ADDENDUM # 2

PROJECT: Fore River Short Stay Hospital, Portland, Maine

PROJECT NO: 05-4898

DATE: December 6, 2006

5 TYPICAL HATCH DETAIL
 SCALE: 1/2"=1'-0"

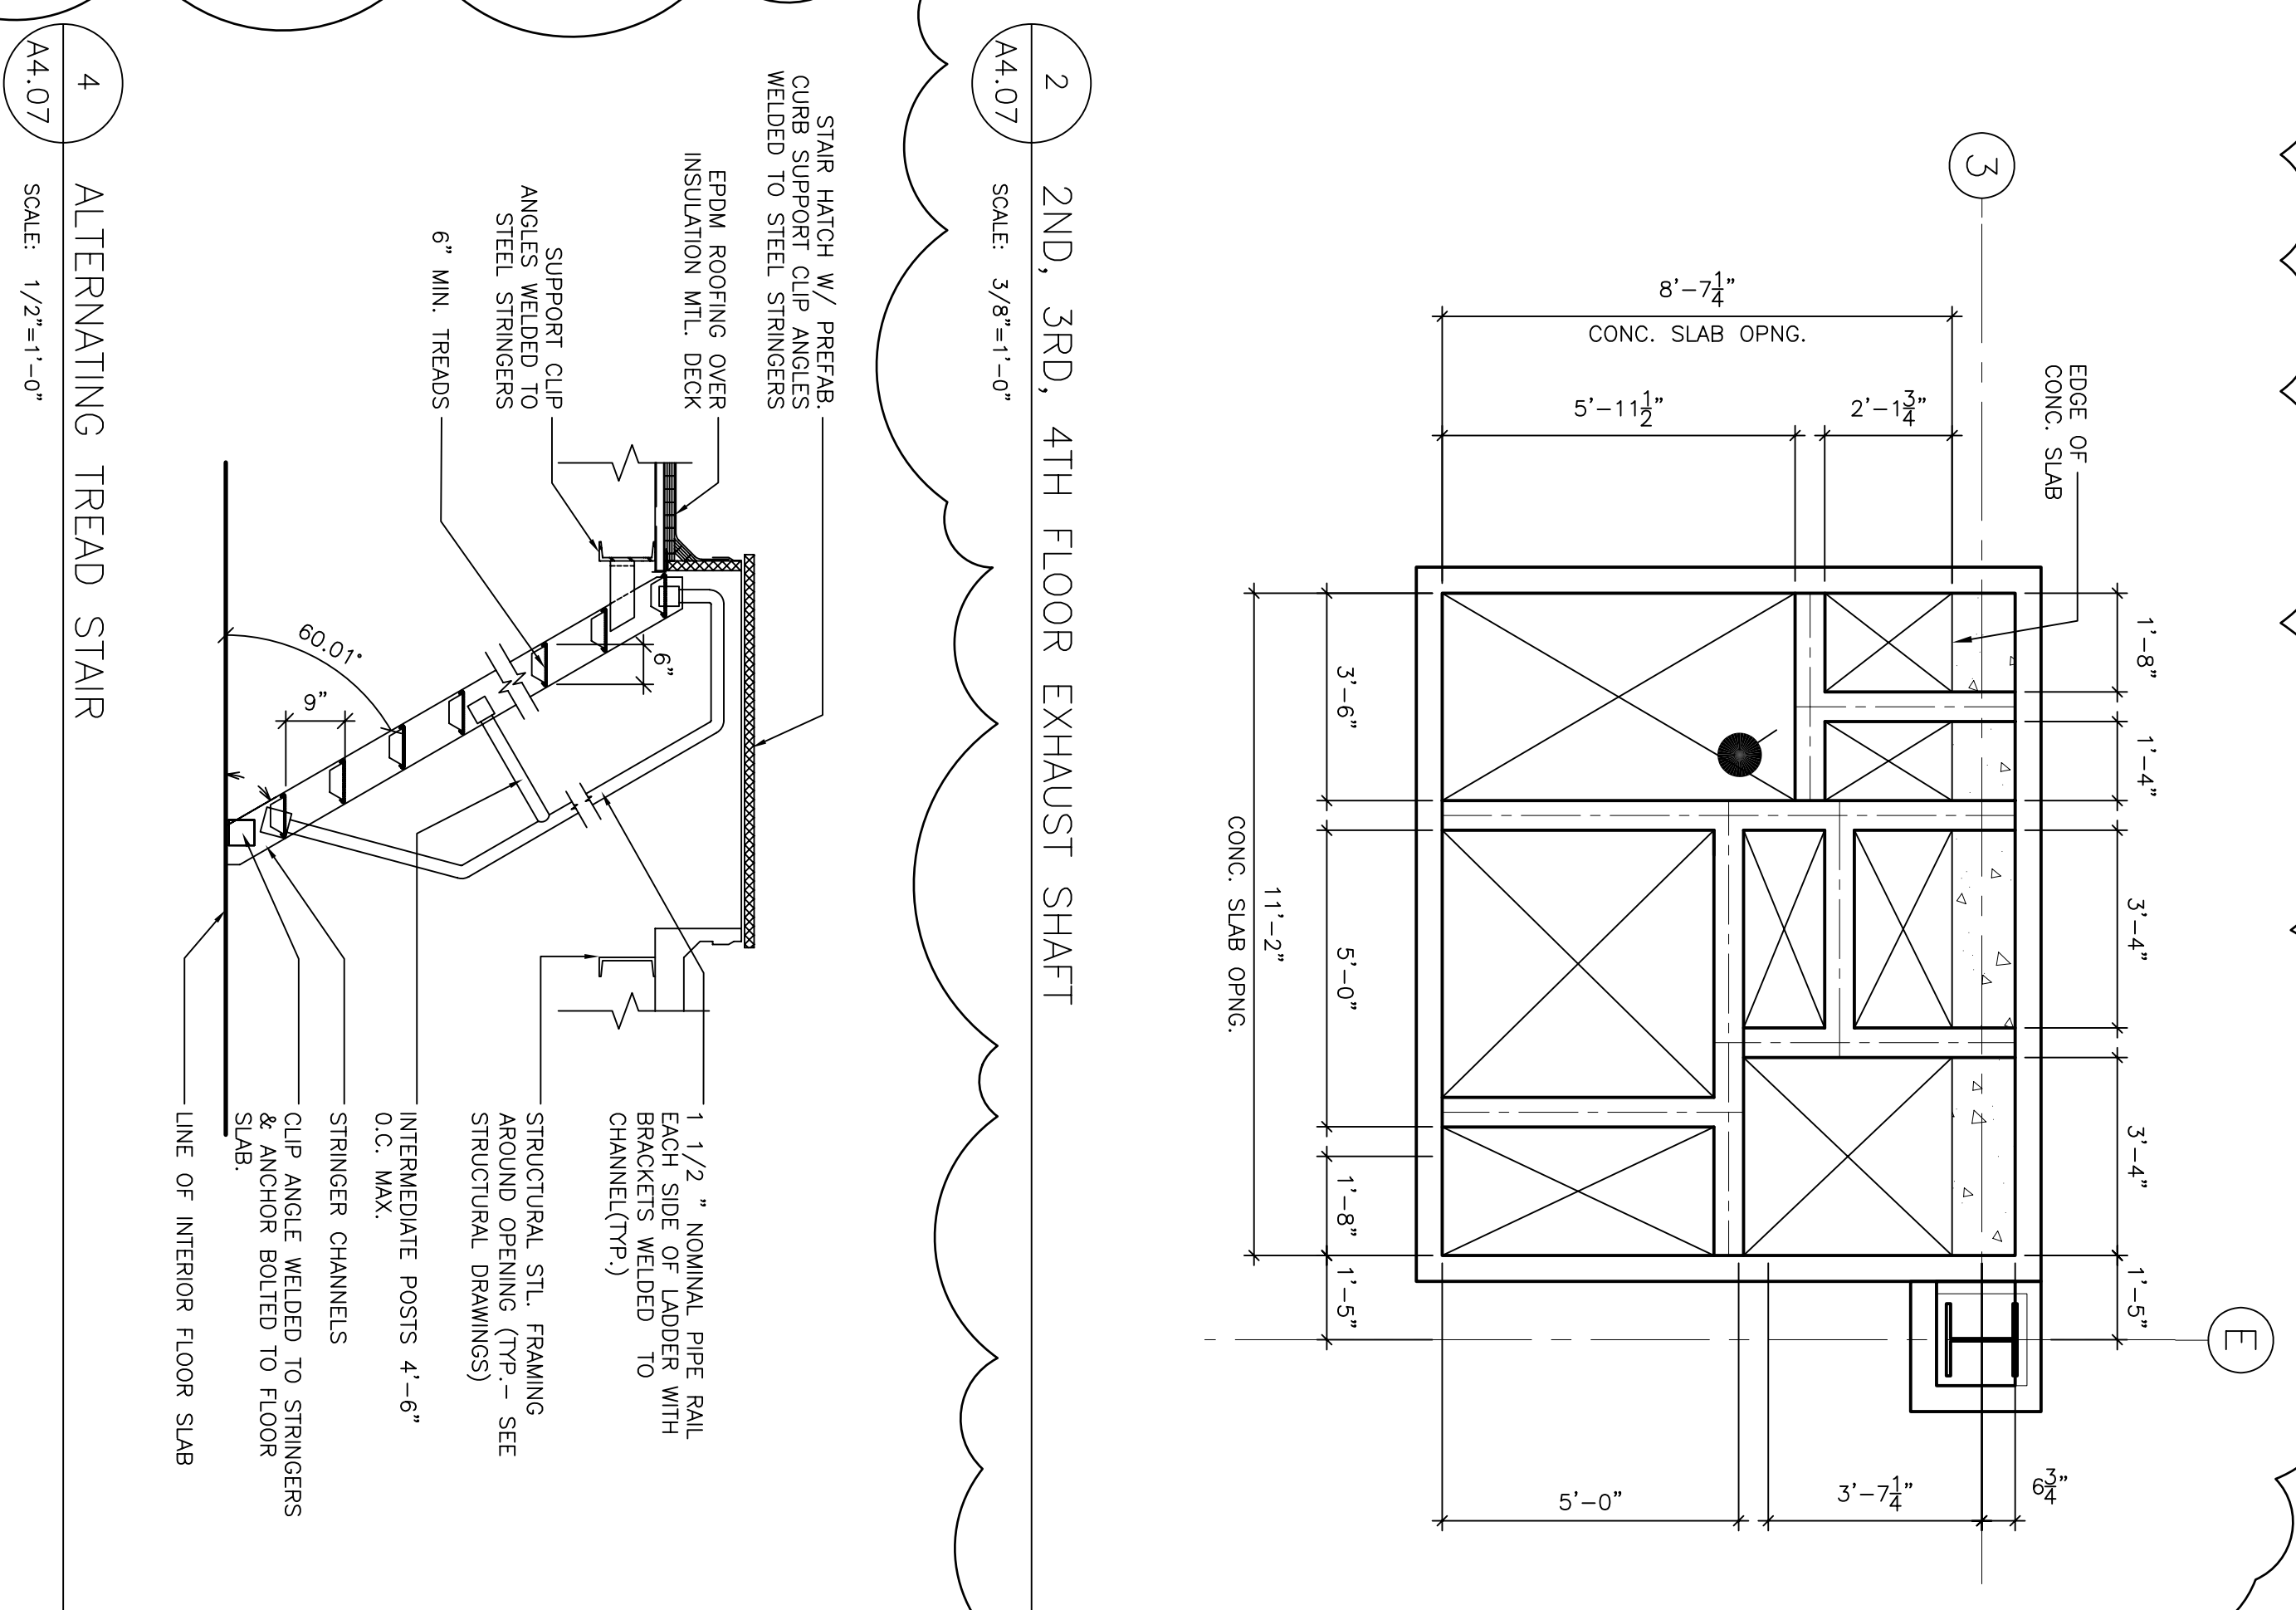
Sketch SKA-27 – Revision – Typical Hatch Detail

1. Deleted Ladder
